REQUEST

Current Zoning: R-3 (single family, residential)
Proposed Zoning: R-17MF(CD) (multi-family residential)

The petition proposes a residential community of up to 213 single family attached townhome style dwelling units.

**STAFF
RECOMMENDATION**

**SCHEMATIC**  
**SITE PLAN**

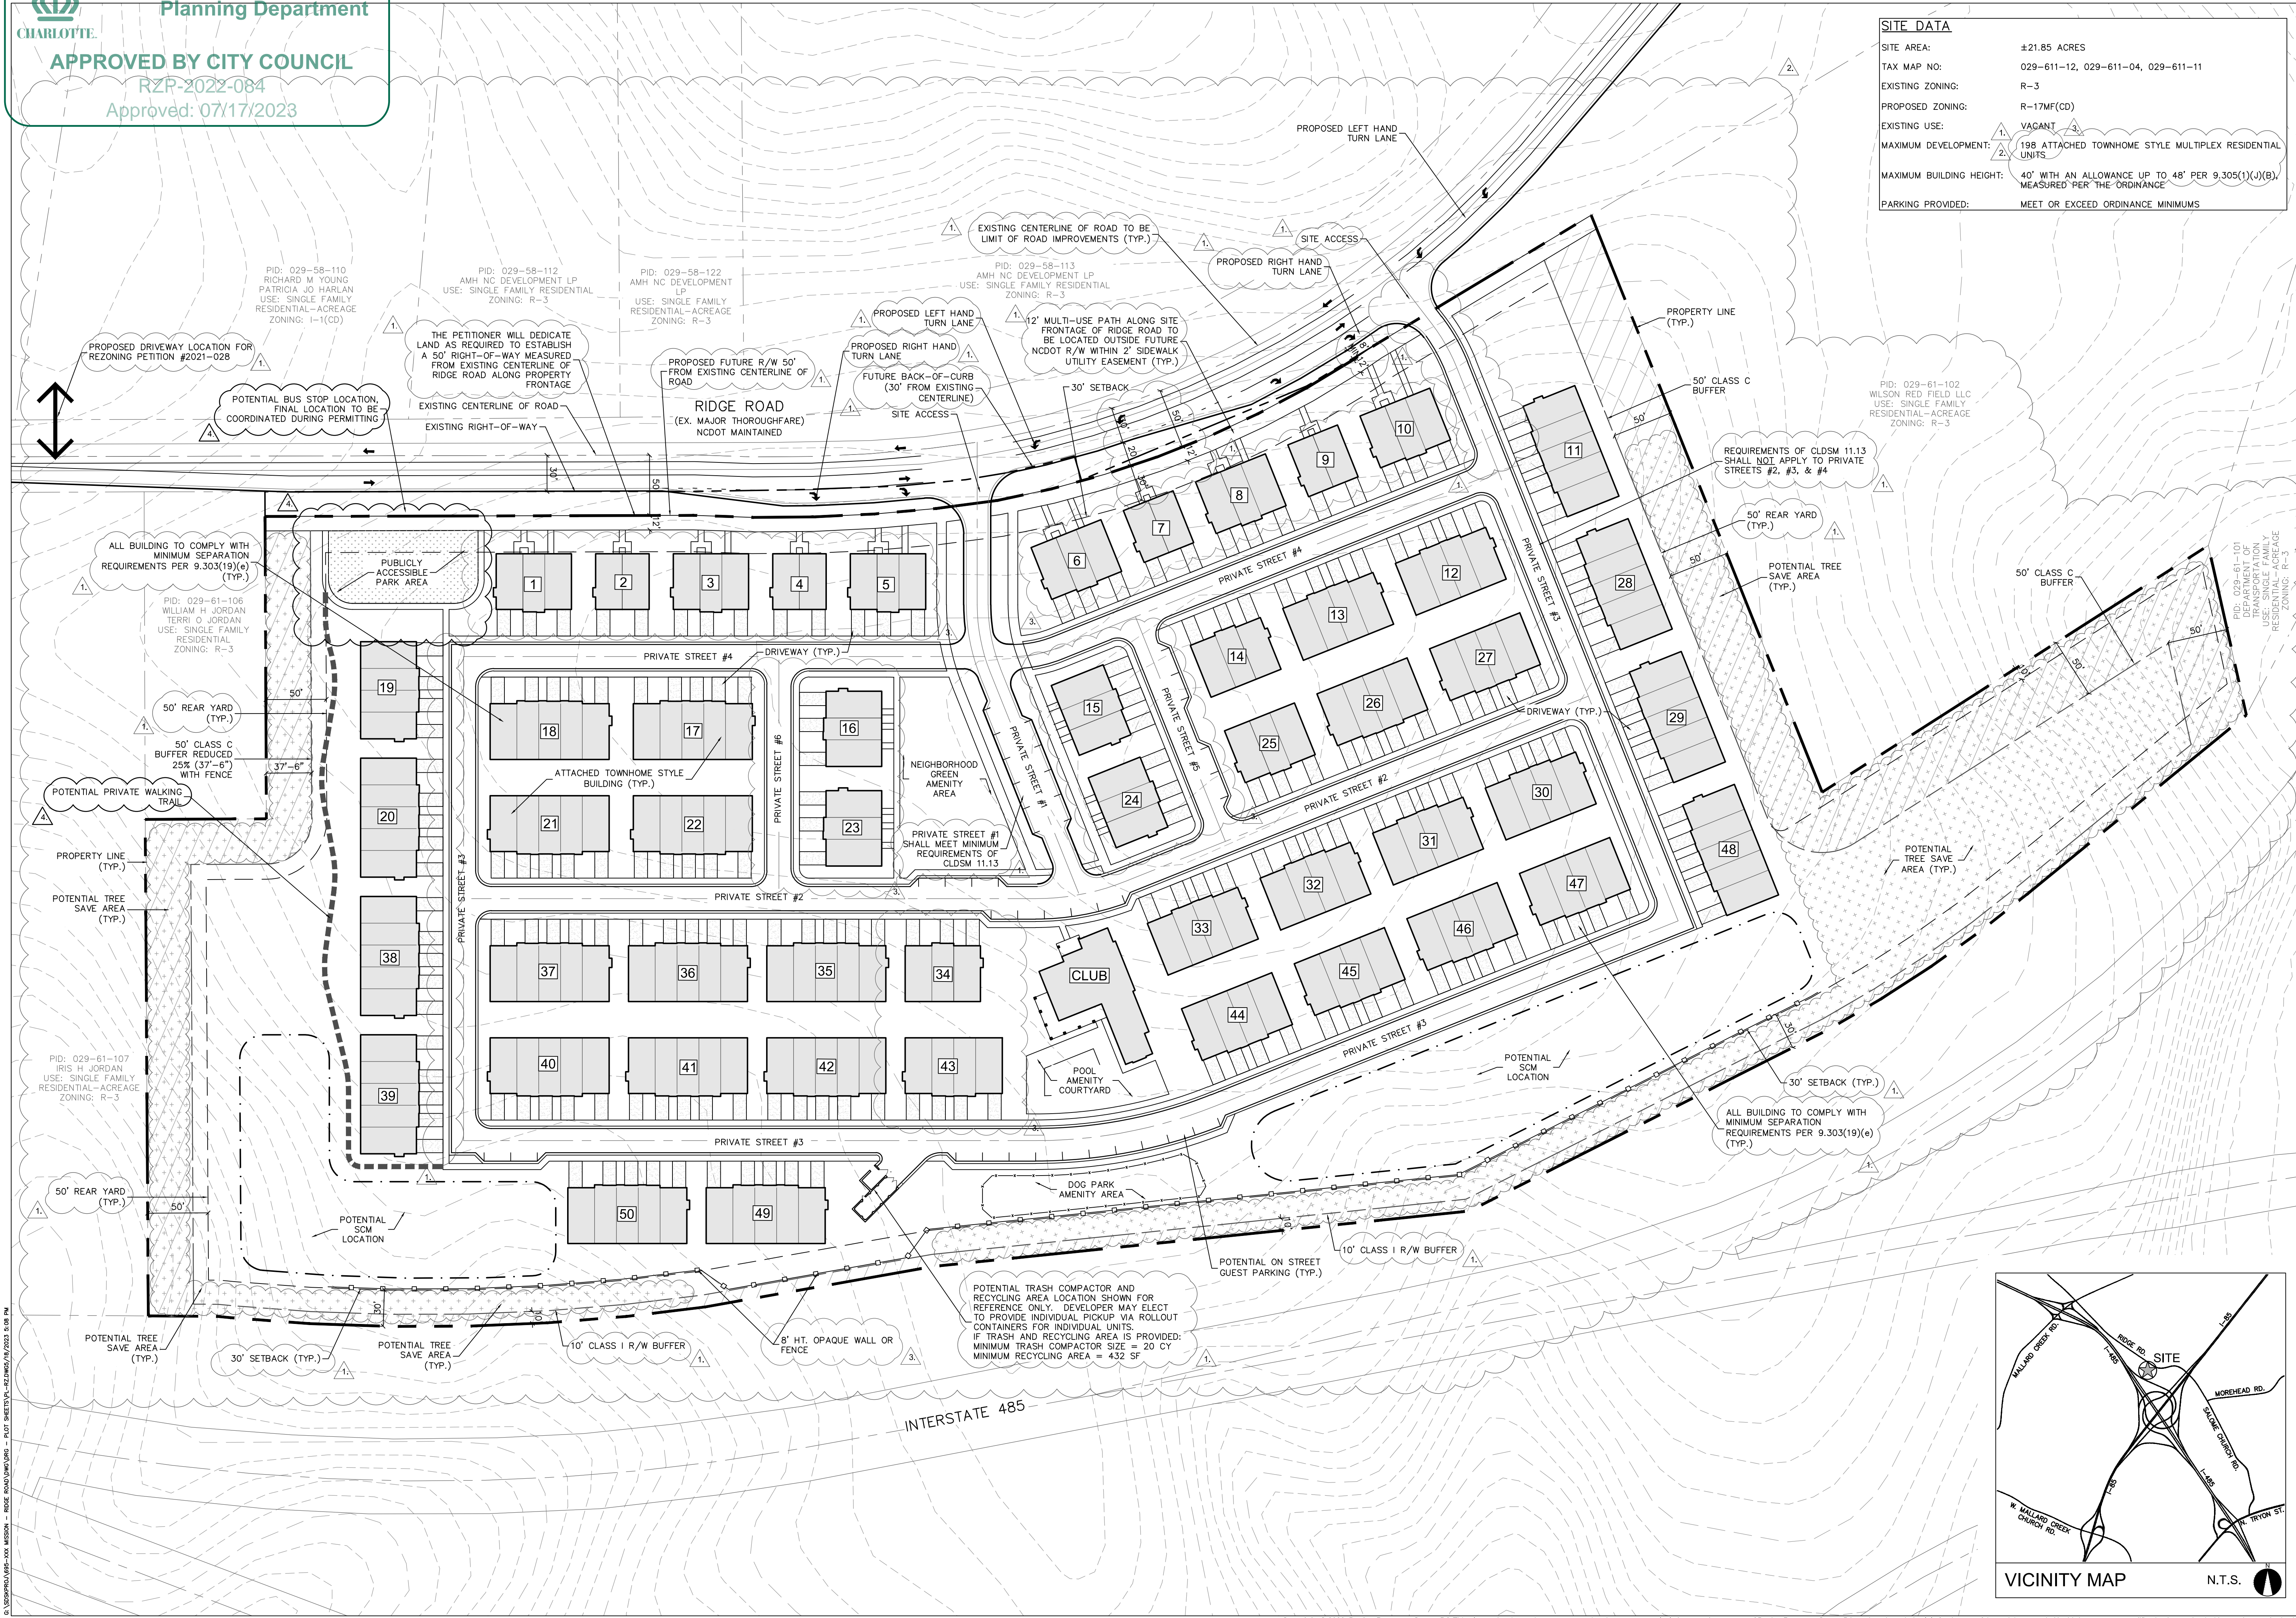
2. Reduce unit count and number of buildings with a mix of single family, duplexes, and triplexes to be consistent with the Neighborhood 1 place type.
